Suffolk County Council (20041323)

Comments on the Outline Written Scheme of Investigation

Bramford to Twinstead (EN020002)

17 January 2024

Reproduced from ordnance survey maps by permission of the Ordnance Survey on behalf of the controller of her majesty's stationery office.
 © Crown copyright Ordnance Survey, Licence no. 0100052046.

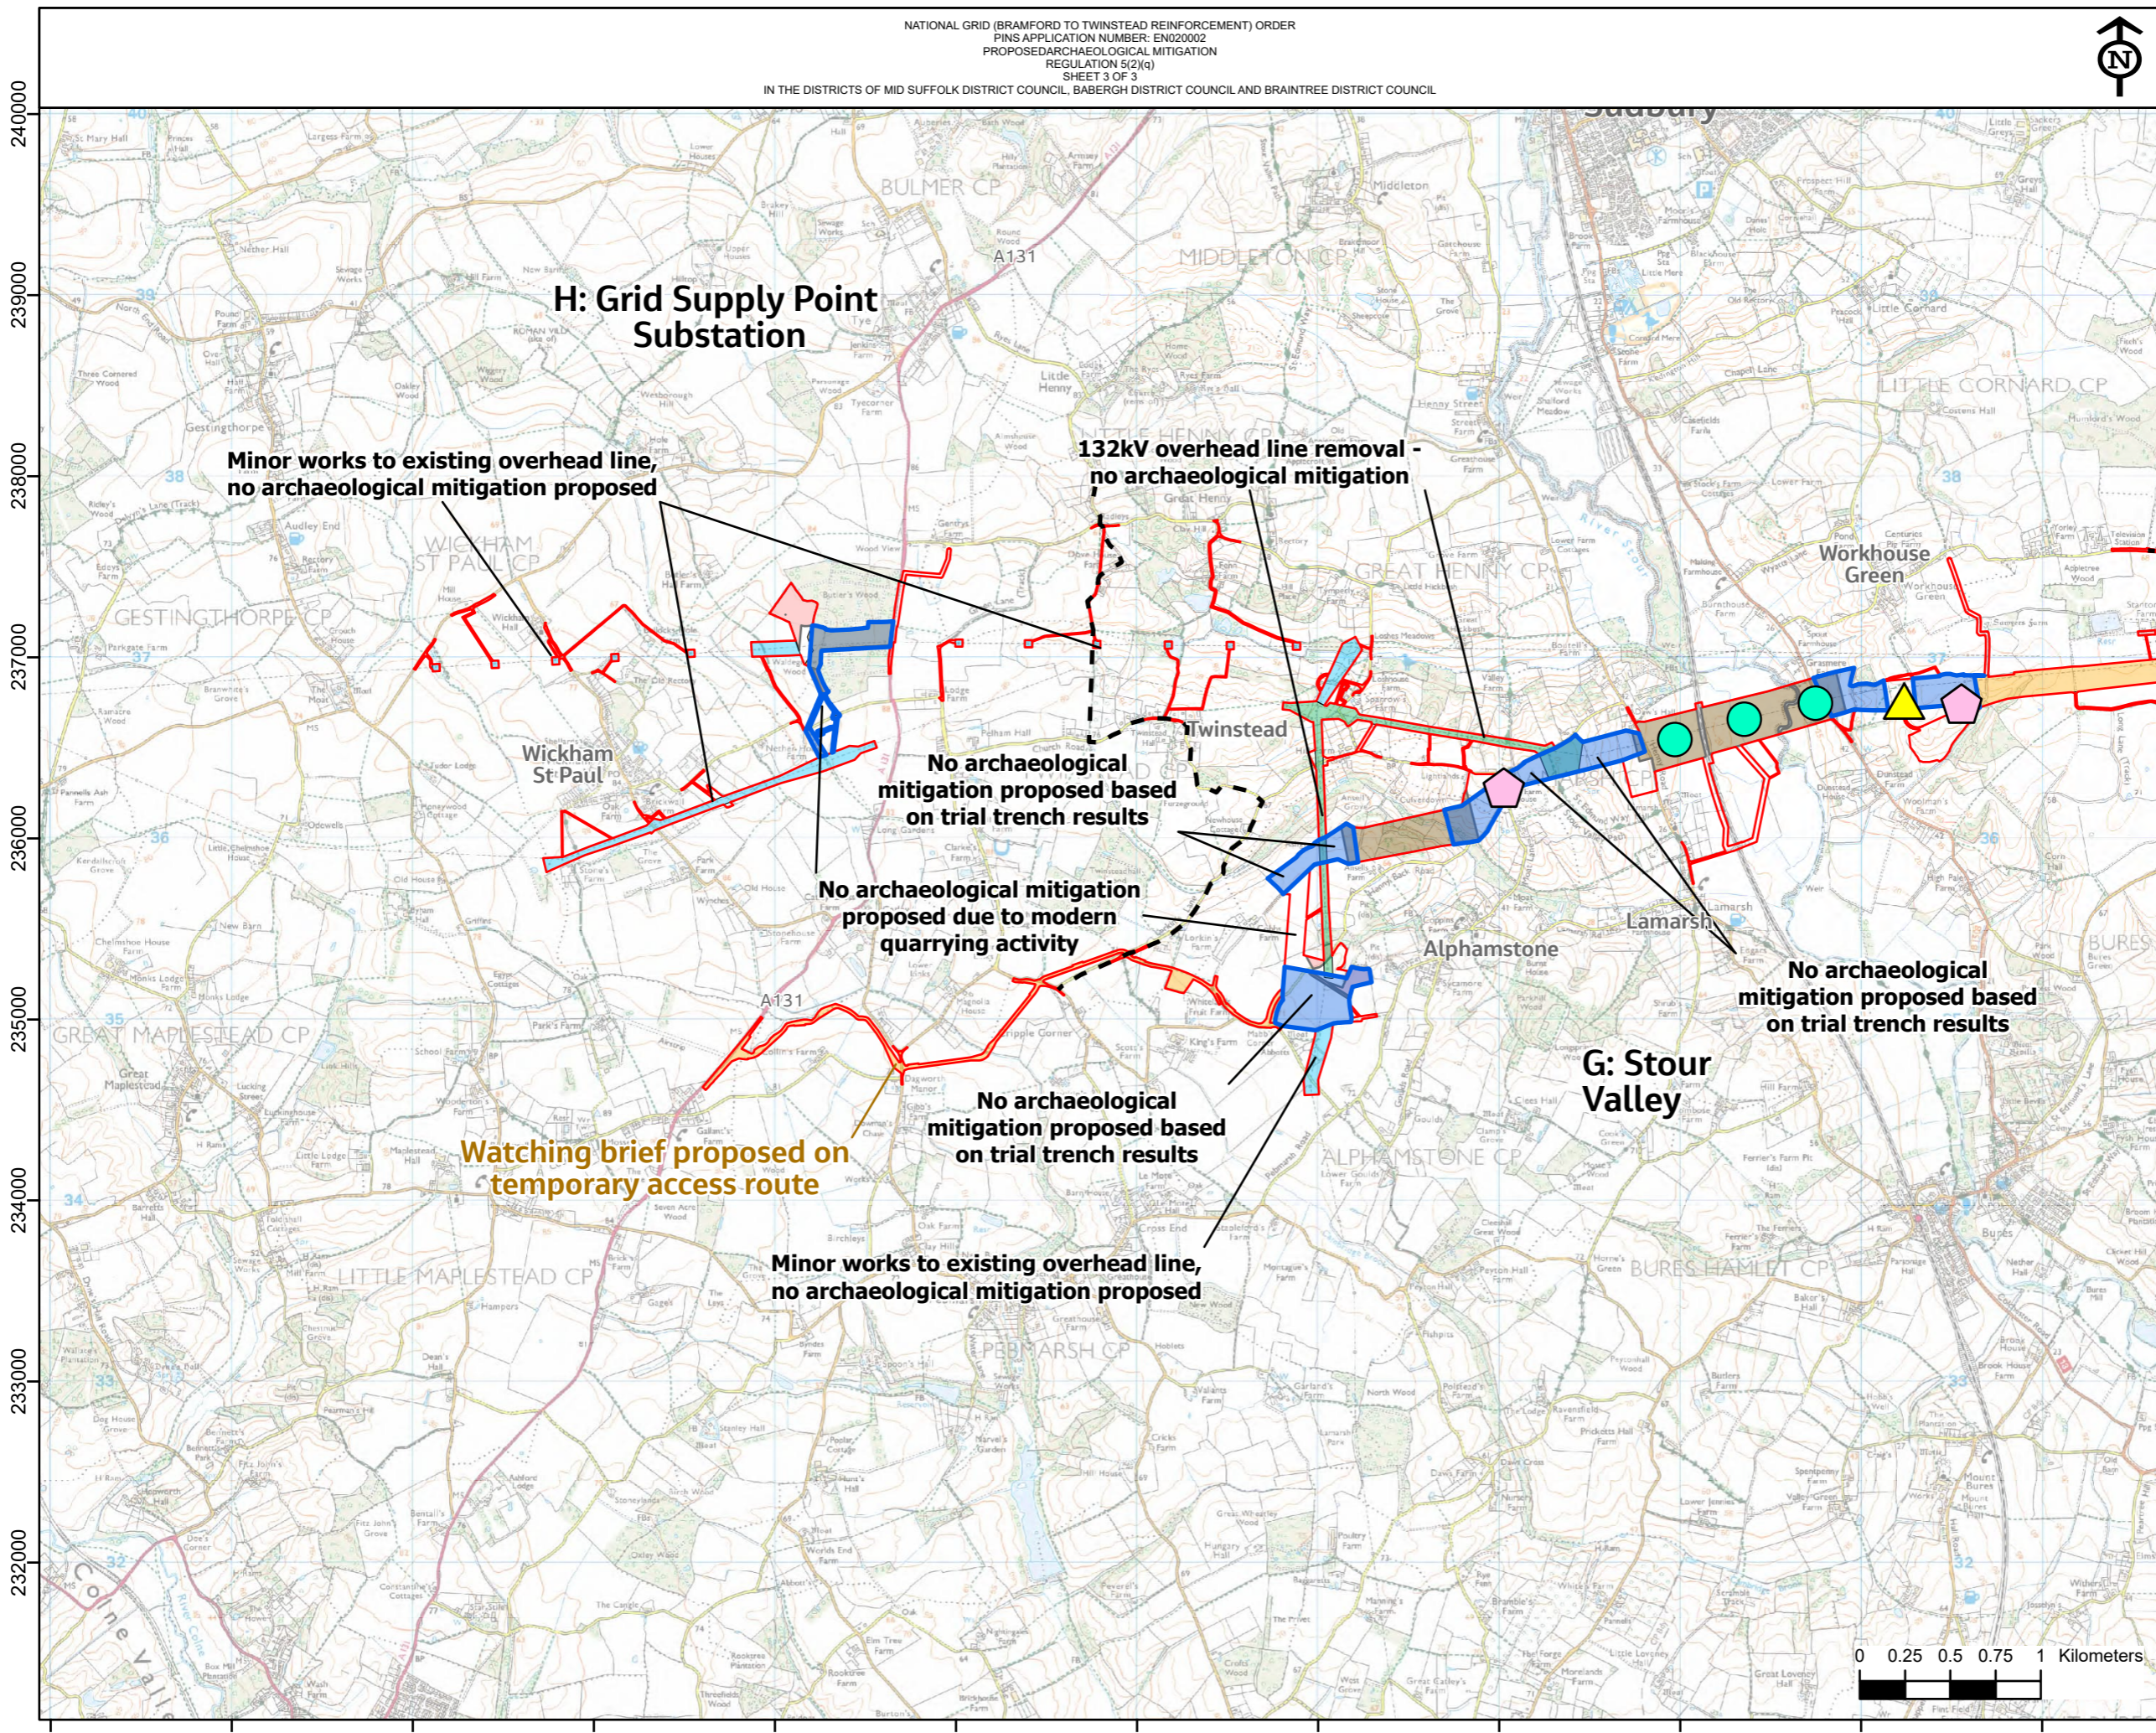
<p>1s</p>	<p>Targeted Archaeological Open Area Excavation – Locations</p>	<p>4.2.1</p>	<p>Currently, targeted Archaeological OAE is proposed in two locations within the Order Limits as shown on Figure 1: Proposed Archaeological Mitigation:</p> <ul style="list-style-type: none"> • Section G: South of Workhouse Green, where evidence from the trenched evaluation indicates an area of Roman activity; and • Section G: Either side of Moat Lane west of Lamarsh, where intensive cropmark activity located in the HER has been tested by trench evaluation and proven to contain Iron Age and Roman archaeology. 	<p>SCCAS have only seen results of the trenched archaeological evaluation for stages 1-4 and have not seen the full results of the fieldwork.</p> <p>See comment for 1.5.1.</p> <p>As there has only been low level of trenched archaeological evaluation within the undergrounding sections of the proposal, at a 2% sample, there is insufficient information to accurately define areas for archaeological mitigation where trenched archaeological evaluation has been undertaken.</p> <p>As a result, there is a need for further trenched archaeological evaluation to be undertaken post-determination for the areas that have not been trenched and in the areas that have been subject to pre-application trenched archaeological evaluation so the archaeological resource can be accurately quantified.</p> <p>The OWSI should therefore be a process document and should not contain details of defined areas for archaeological mitigation. Instead, the OWSI should state that there will be archaeological mitigation required to be undertaken prior to the construction phase, which would be defined in Detailed Written Schemes of Investigation (DWSI). Areas for archaeological mitigation by OAE should include:</p> <ul style="list-style-type: none"> • Area G1 – an initial 40mx40m excavation area around two probable Late Bronze Age – Early Iron Age cremation burial which could be part of a cremation cemetery in and around Trench G1.49. there may be a requirement to extend the excavation area further depending on the archaeology present. It is not uncommon for cremations of this period to be focused around or in the vicinity of earlier burials/funerary

1x	Archaeological Strip, Map and Sample - Locations	5.2.1	<p>SMS will be applied in areas of the project where the presence of archaeological remains warrant preservation by record and the project is anticipated to require topsoil removal. Areas identified for SMS are shown on Figure 1: Proposed Archaeological Mitigation and include: National Grid December 2023 Bramford to Twinstead</p>	<p>Same as comments as for 4.2.1.</p>
